PDA/684/685
Jai Shankar
8745 9765

17 July 2017

**PRE-DEVELOPMENT APPLICATION ADVISORY PANEL MEETING
68 FOWLER ROAD, MERRYLANDS (MERRYLANDS PUBLIC SCHOOL) & 781
MERRYLANDS ROAD, GREYSTANES (GREYSTANES PUBLIC SCHOOL)**

Figure 10 Extract of building height plane diagram (JDH Architects)

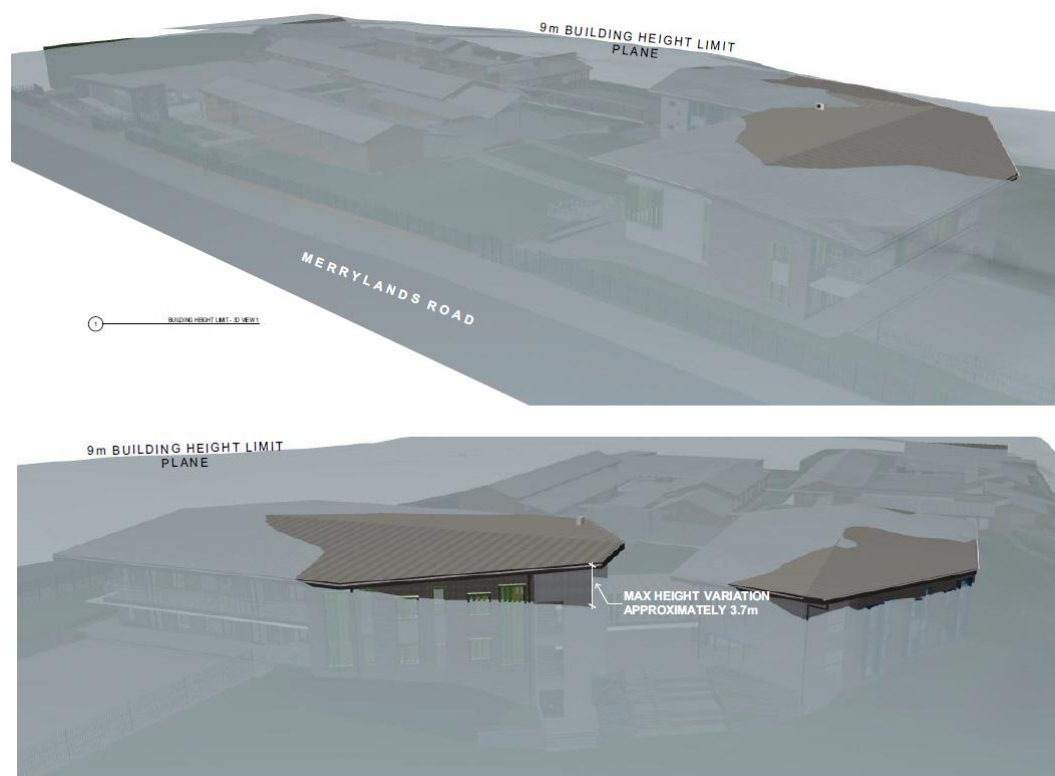
- (ii) The height of the buildings shall be restricted to a maximum of 9m as required by the Holroyd LEP 2013 where practical and possible. Both schools propose new buildings greater than 9m in height. Consideration shall be given by Council to the non-compliant height if it can be demonstrated that the excess height will have no amenity impacts upon the adjoining developments in terms of visual/acoustic privacy, solar access and the streetscape. Consideration should be given to the newly proposed buildings maintaining the maximum height of any existing buildings on the site.

The provided documentation identifies that there will be a non-compliance with the maximum building height (9m) of the new classroom building. It appears this non-compliance occurs to (a portion of) the rear part of the building only – which backs onto residential dwellings (of Bradman St). The non-compliance value and the part of the building affected would need to be specified in DA documentation - using the plans provided the exceedance appears to be about 2m at one point. The justification for this non-compliance will need to be provided with any design, landscaping or other mitigations that are proposed that will redress the building height including as perceived from the Bradman St residences (which are at a lower elevation).

Figure 12 Extract of Cumberland Council's Flood Map (Jones Nicholson)

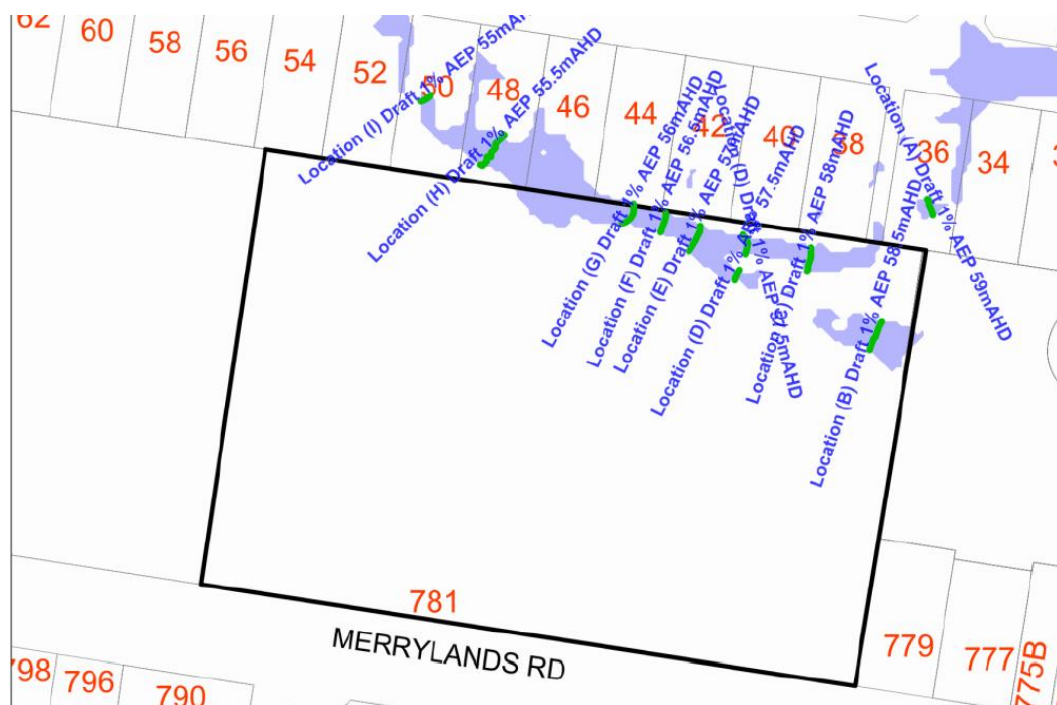
- (v) Part of the Greystanes Public School site is flood affected. In this regard, Clause 6.4 – Flood Planning of the HLEP 2013 shall be addressed. See detailed notes under “Development Engineering” section of this letter.

- (i) The site is shown as a flood control lot on Council’s mapping. All works (e.g. walls, fill structures) shall be kept clear of the 1% Annual Exceedance Probability (AEP) storm event inundation area and the following shall be addressed:

Figure 13 Extract of networked intersections for traffic modelling (ARUP)

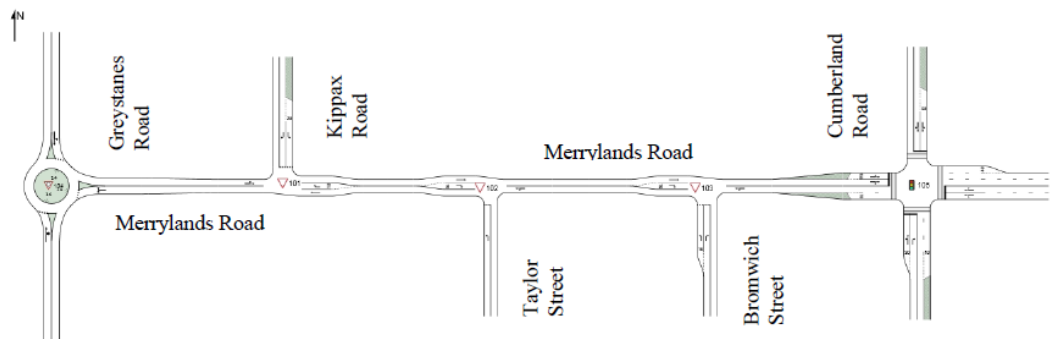
- Analysis of surrounding intersections to identify any impacts on performance and any proposed measures to mitigate the impacts including the following:

- Merrylands Road with Cumberland and Greystanes Road, and with Bromwich, Taylor and Kippax Streets.
- Analysis of surrounding intersections to identify any impacts on performance and any proposed measures to mitigate the impacts including the following:
 - Fowler Road with Mathew, Desmond and Bristol Streets
 - Holdsworth and Harris Streets, with Morris and Matthew Streets
 - Chetwynd Street, with Morris and Matthew Streets.

Figure 14 Extract of drop-off and pick-up arrangements, with potential additional future access (ARUP)

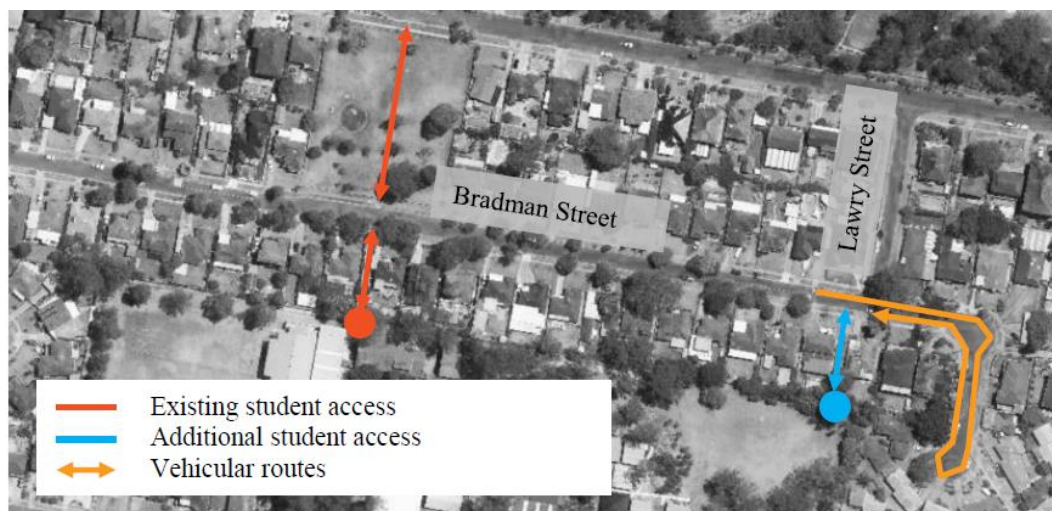
- Details of pick up/ drop off areas and impact of the additional students and vehicles on pick up/ drop off areas shall be provided.
- Details of parking layout and access driveway shall be provided.
